**DEVIATION REVIEW  
 AND DECISION FORM**

Subdivision or Project Name: Meadowbrook Crossing

Section of ECM from Which Deviation is Sought: 2.3.3.F.3

Specific Criteria from Which a Deviation is Sought: Minimum tangent length between broken back curves on a Local roadway

**MEADOWBROOK CROSSING
PREBLE DRIVE AND BOREAL DRIVE PLAN AND PROFILE
STA. 24+50 TO STA. 35+00
EL PASO COUNTY, COLORADO**

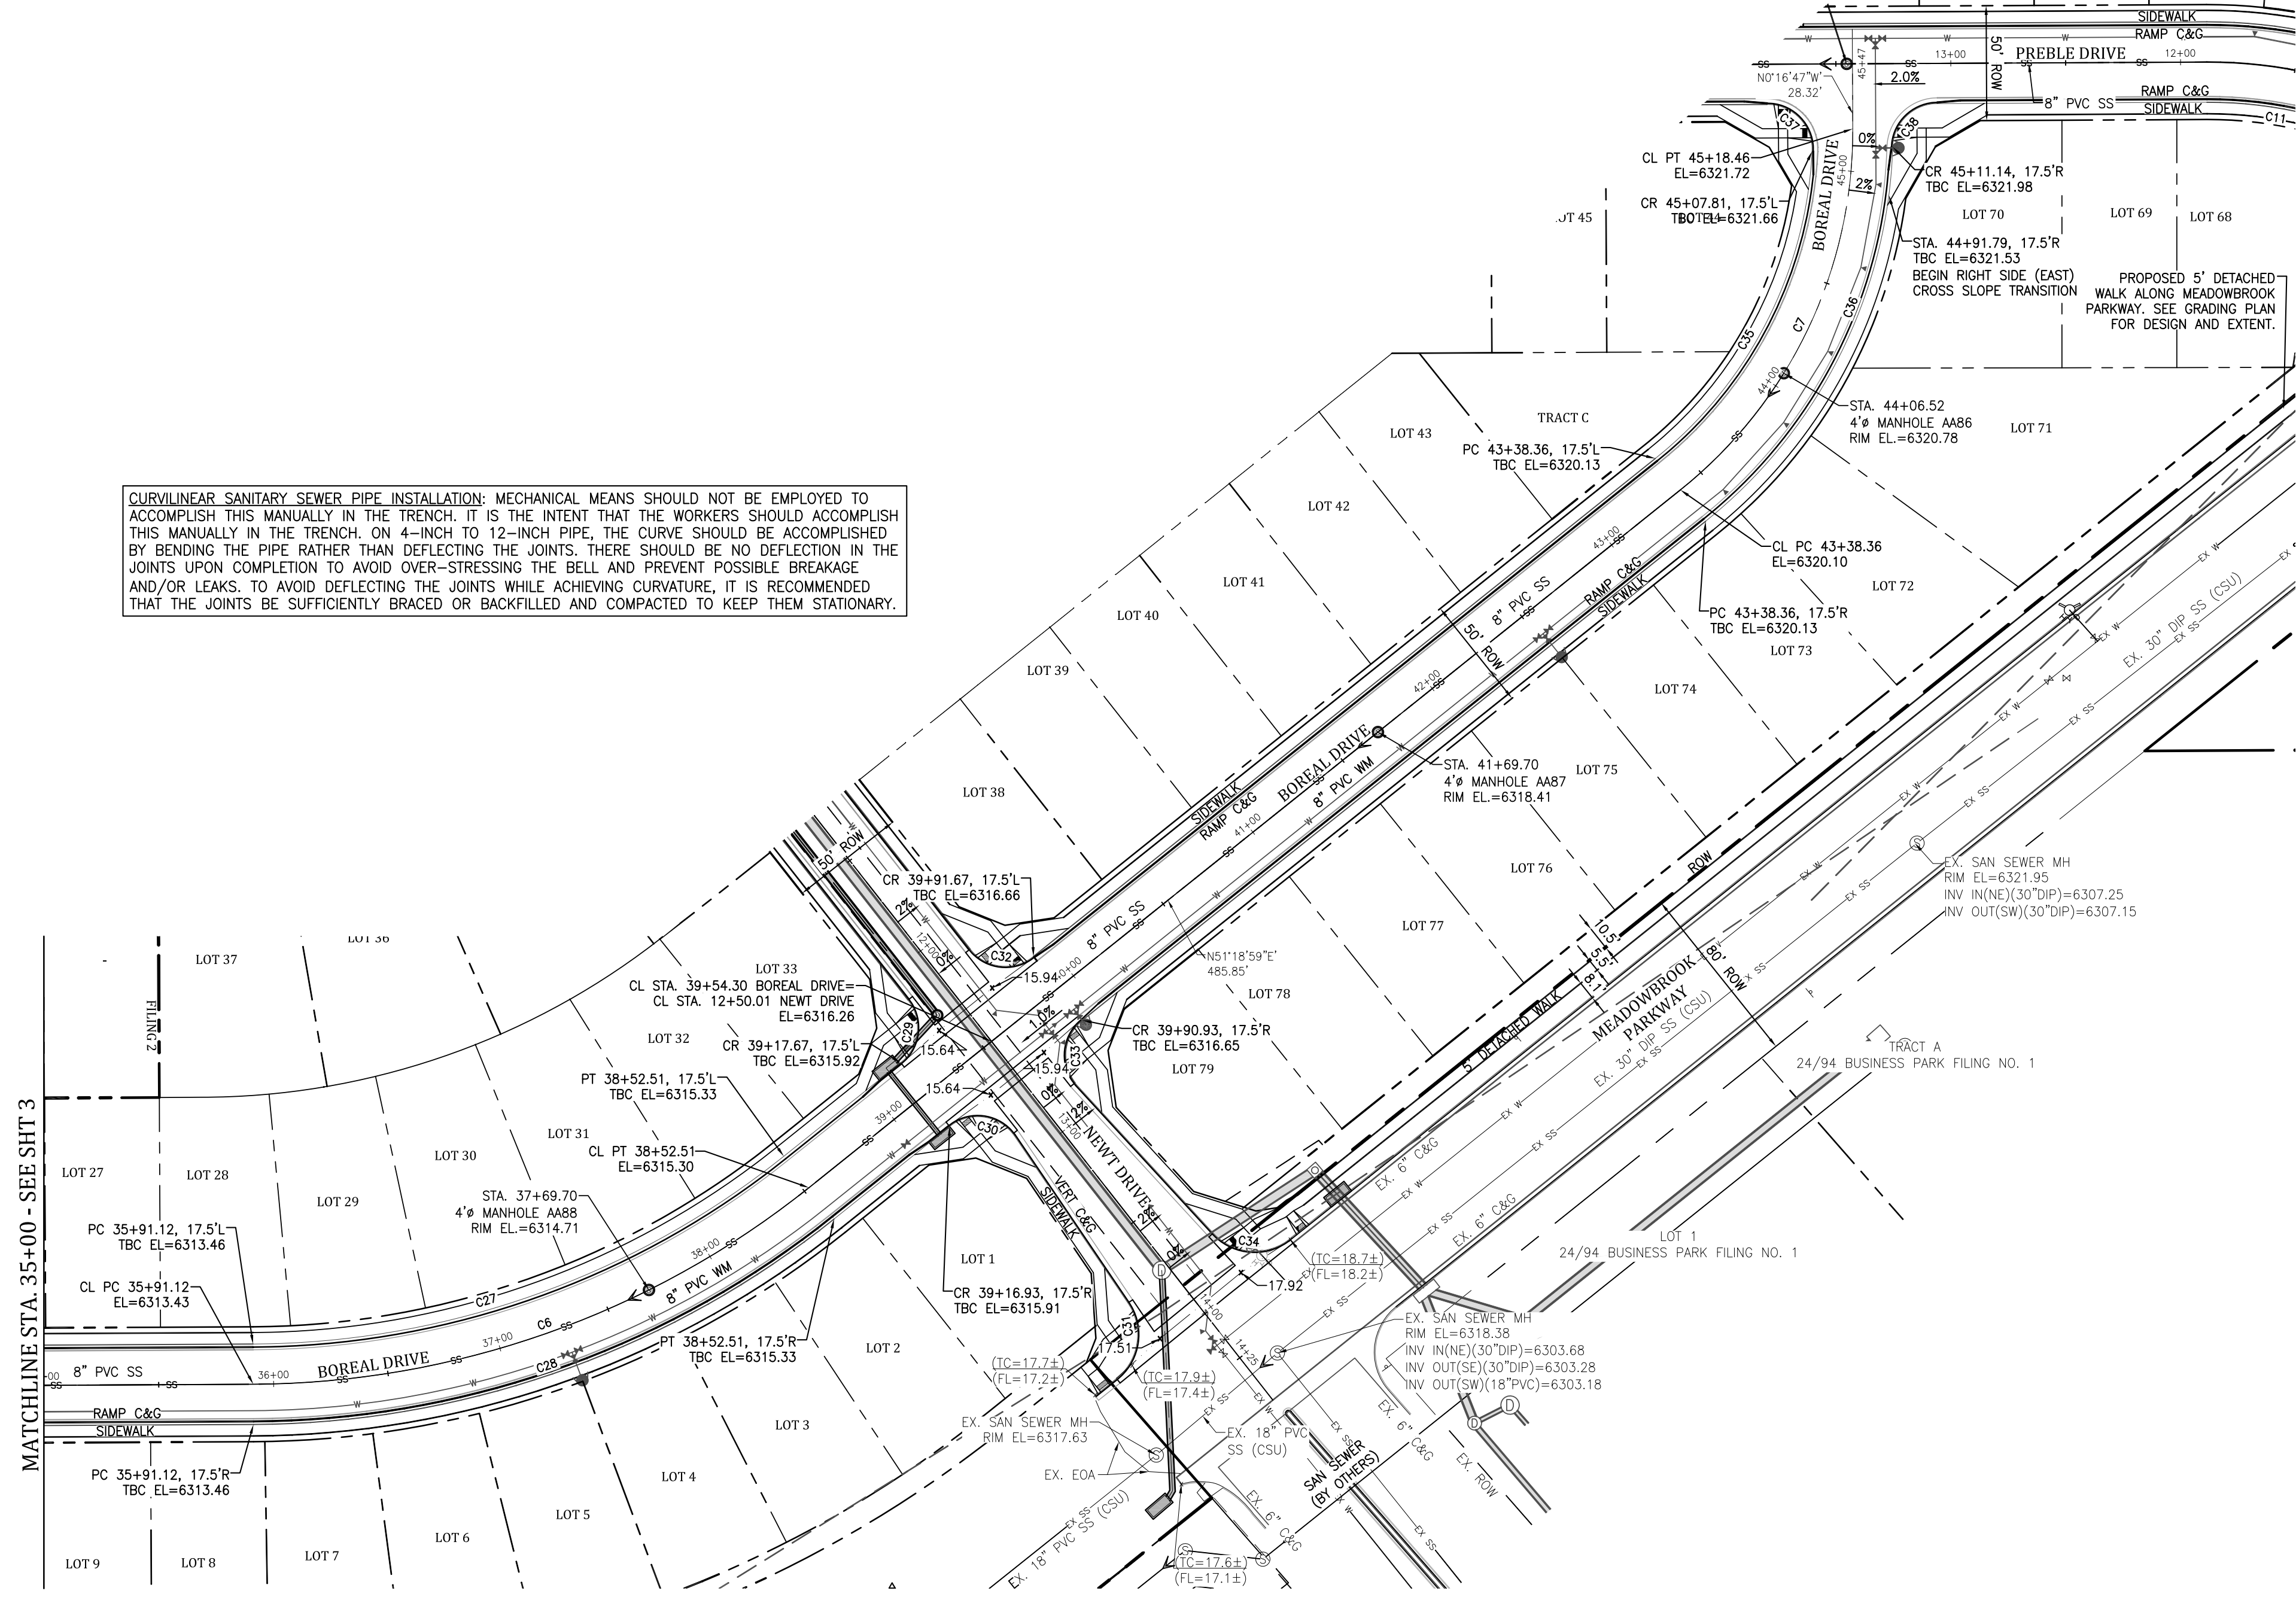
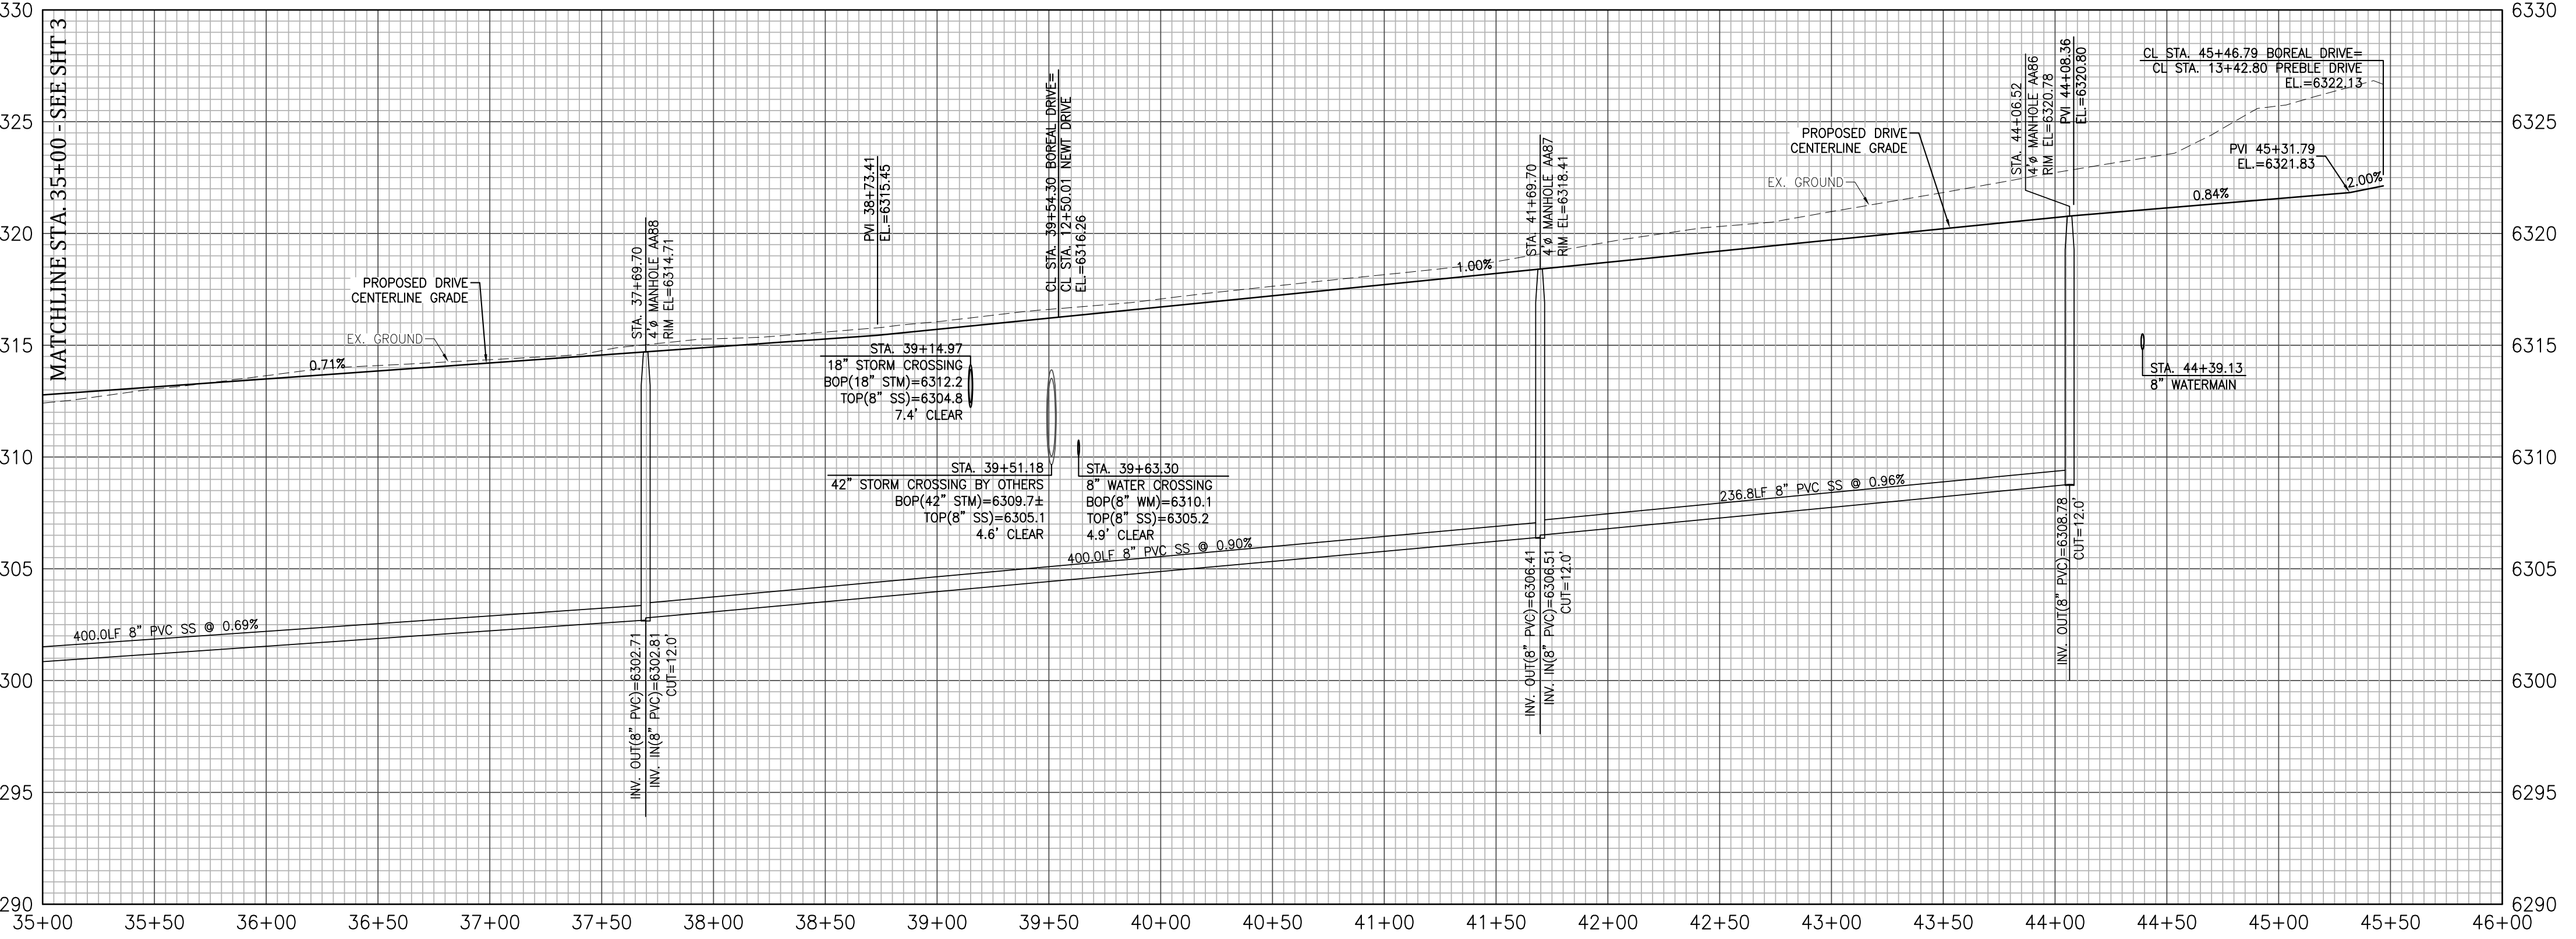
Proposed Nature and Extent of Deviation: The request for a deviation is to adjust the centerline tangent length between the two broken back curves on Boreal Drive (Urban Local) located at the western portion of the property from the required 200 feet to the proposed 146 feet as illustrated on the drawings.

Reason for the Requested Deviation: This area of the site contains several constraints that cannot be mitigated. These constraints include the location and width of Meadowbrook Parkway; the location of Sand Creek and its improvements; and the location of the 30-foot Sanitary Sewer Easement running parallel with the creek. All of these constraints combined narrow and limit the amount of developable area in this portion of the site. As a result, the 200-foot minimum tangent length is not achievable given the available width. The lot sizes are as small as they can be in order to remain buildable and effective. In addition, the lack of available width prevents the ability to completely line the street with units as shown on the drawings.

Comparison of Proposed Deviation to ECM Standard: The requested tangent length is 146 feet which is 54 feet less than the ECM standard of 200 feet.

This shortened roadway tangent will not be a high traffic area nor will it become a through way as only a handful of homes are served by this looping local street. Moreover, this situation is for two 90-degree curves with 50-foot centerline radii (combined with corner knuckles) which will have design speed of about 15 mph.

Review and Recommendation:  
APPROVED by the ECM Administrator
